# Longfield Solar Farm

Statement of Common Ground – National Highways

PINS Reference: EN010118

Document Reference: EN010118/EX/8.4(A)

Appendix B – Surrounding Highway Network

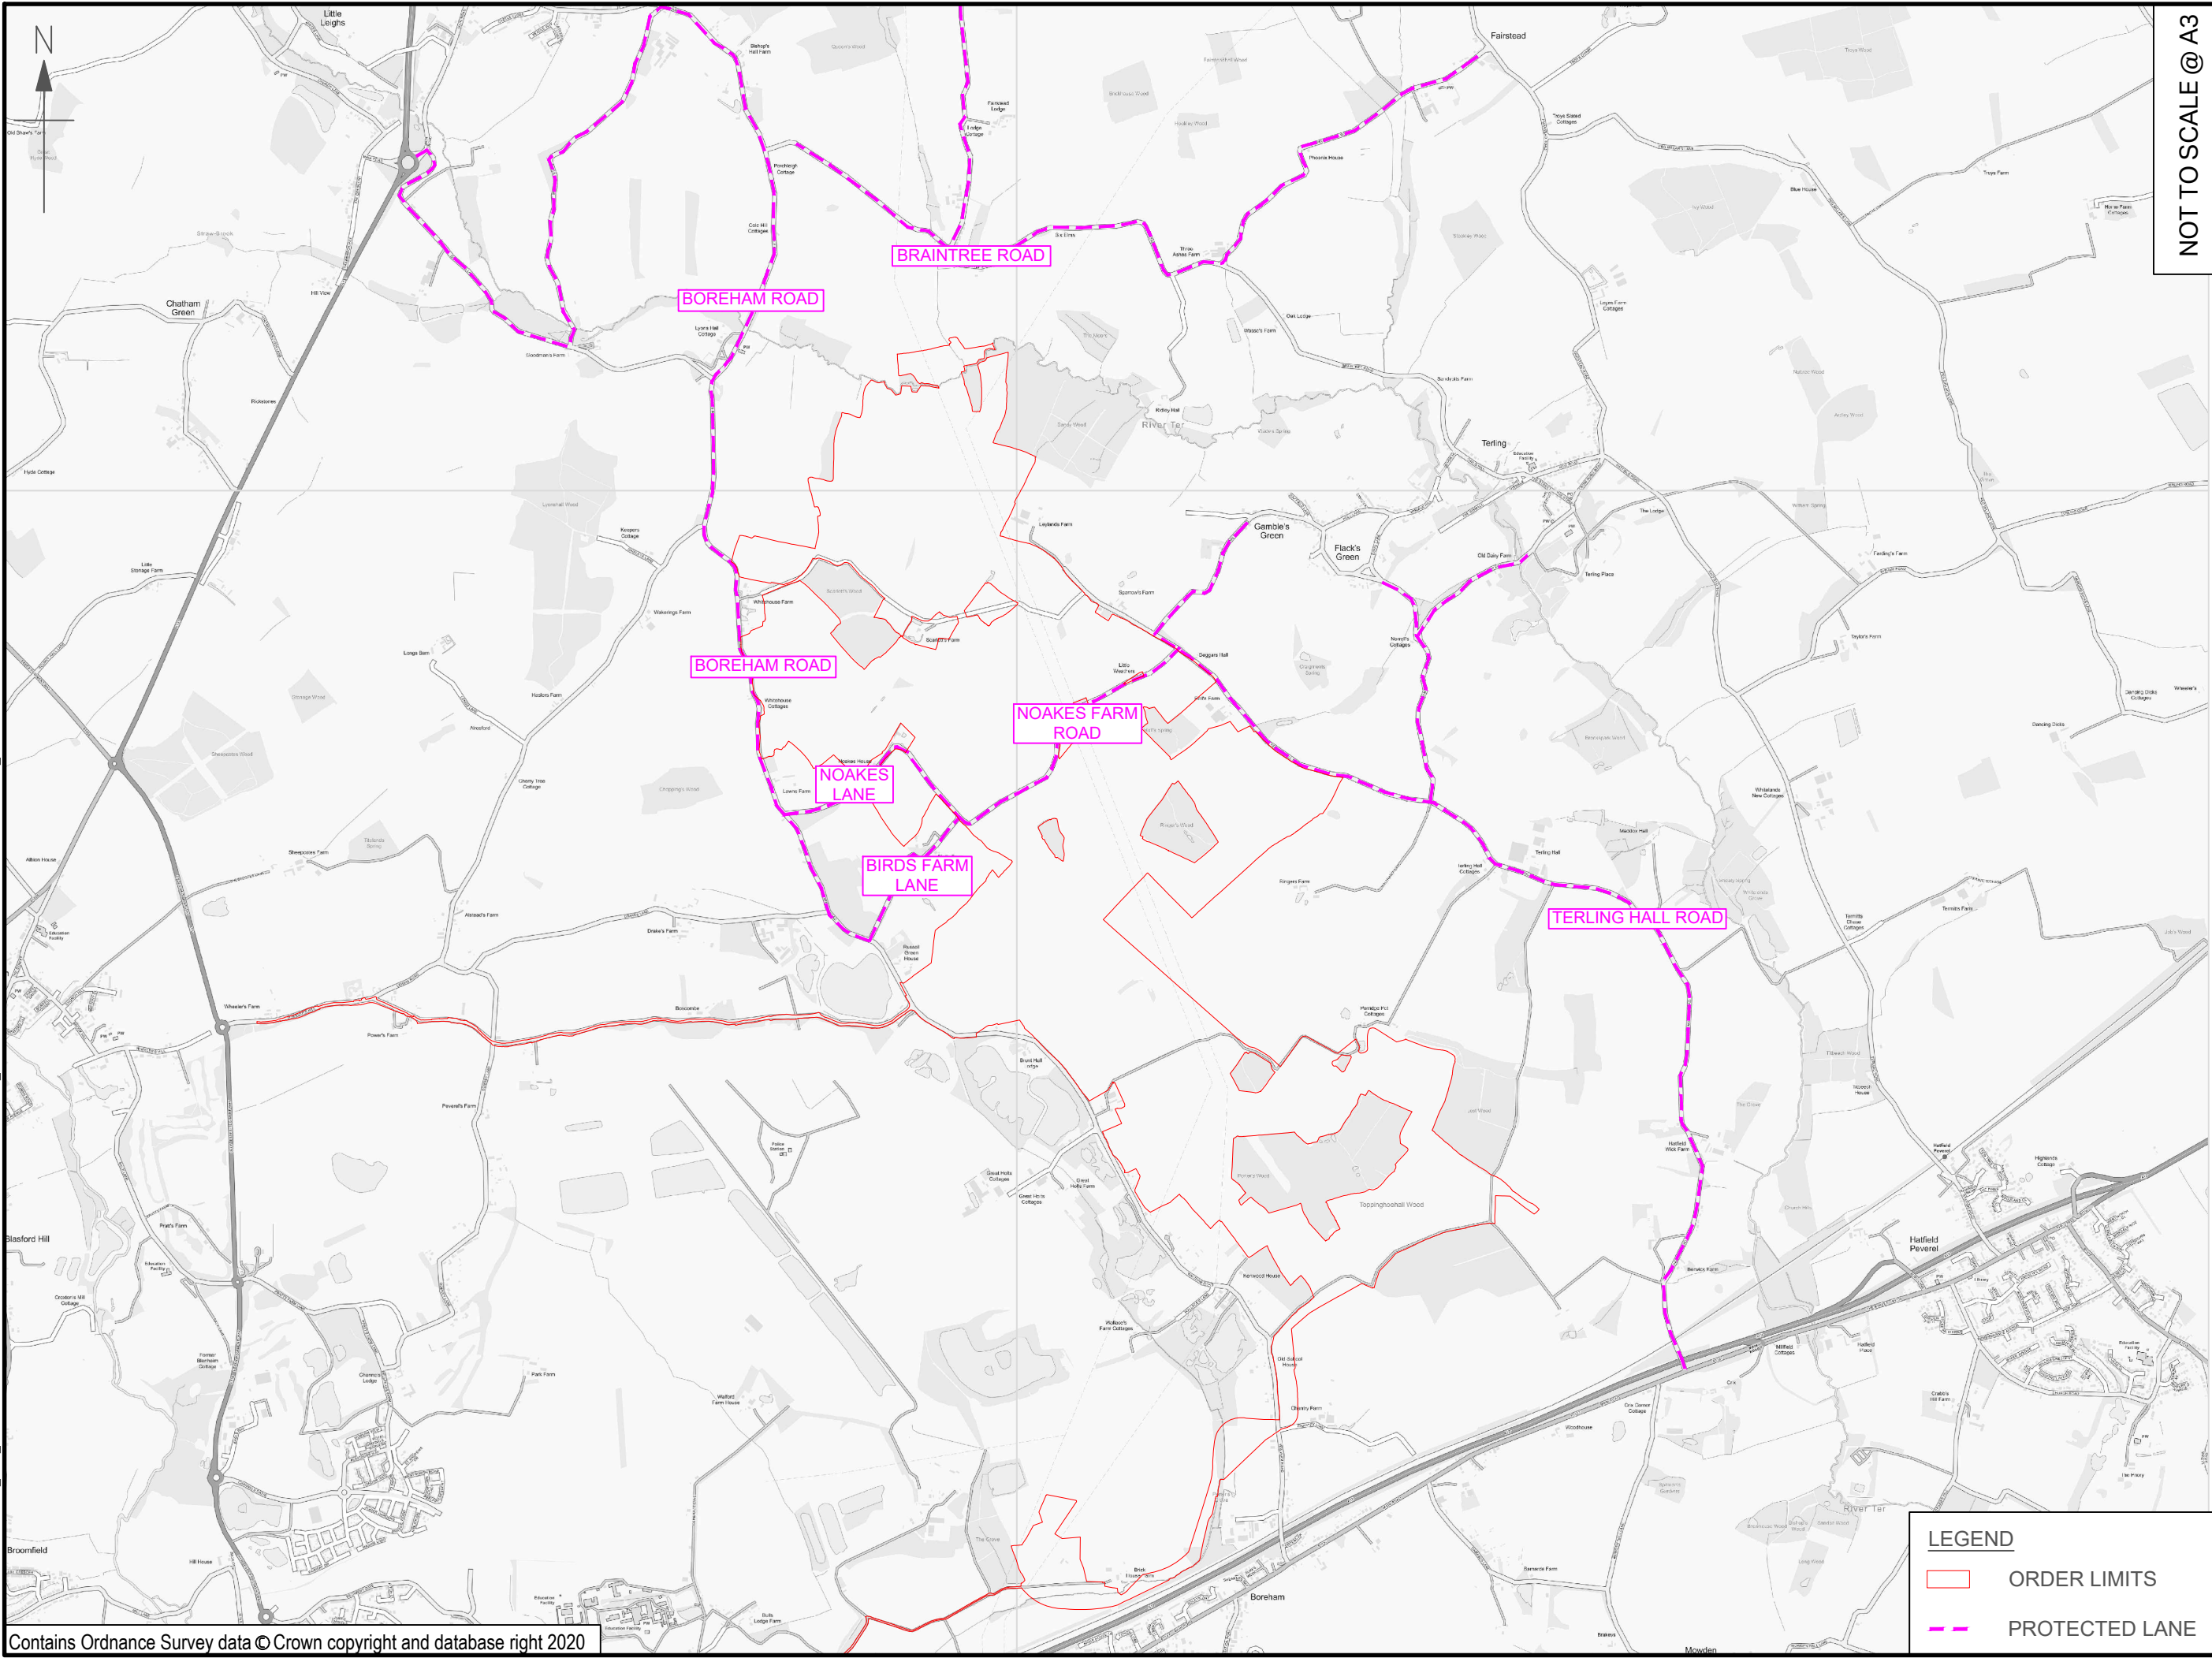
4.9	<p><b>Private Road to/ from Bulls Lodge Substation</b></p>	<p>As mentioned in the Framework CTMP and shown in 'Appendix B – Surrounding Highway Network', Longfield Solar Farm proposes to utilise a private road via Boreham Interchange/RDR for Bulls Lodge Substation compound and construction. The A12 Scheme also proposes to utilise this private road's access for construction purposes including a haul route, compound and lay down area and soil storage. Effort is being made between both parties to ensure the private road is shared between both schemes during construction, working together to agree and establish this in the SoCG.</p> <p>However, there remains uncertainty with regards to the status of the private road. The private road is currently owned by Countryside Zest (Beaulieu Park) LLP and is expected to become an adopted highway upon completion of the Beaulieu Park development, the timing of which is unknown. Prior to the adoption of the highway, it is still to be agreed which entity will act the Principal Contractor, therefore highway rules to be complied with remain uncertain (i.e. speed limits, access controls). National Highways and Longfield Solar Farm are working together to agree and establish this in the SoCG. Additionally, National Highways are seeking to ensure access is retained from the RDR/private road to A12 site for construction purposes.</p>	<p>It is acknowledged that there will be a requirement for both schemes to share the private road to/ from Bulls Lodge Substation during construction. Measures to manage construction vehicles along the private road are set out within the Longfield Solar Farm Framework CTMP [EN010118/APP/6.2(A)]. Measures to manage construction vehicles along the private road will also be set out within the A12 Scheme Outline CTMP. Access between the RDR, private road and the A12 will be retained for both schemes, including with respect to the order limits for the proposed haul route, compound and lay down area and soil storage for the A12 to A120 Widening Scheme.</p> <p>Further discussions to be held once the Principal Contractor has been determined.</p>	<p><b>Under Discussion</b></p>

Ref	Sub-topic	Stakeholder Comment	Applicant's Response	Status
		<p>National Highways will seek to implement this as a requirement within LSF DCO if necessary. There is a need for agreement to be sought prior the Applicant's DCO decision to ensure appropriate maintenance and liability responsibilities in relation to the impact of the use of the private road for the construction of the Proposed Development and the A12 Scheme are in place prior to any construction programme beginning.</p> <p>[Jacobs on behalf of National Highways Relevant Representation (for the A12 Chelmsford to A120 Widening Scheme), June 2022] [National Highways Written Rep, Paragraphs 7.2 to 7.4, August 2022]</p>
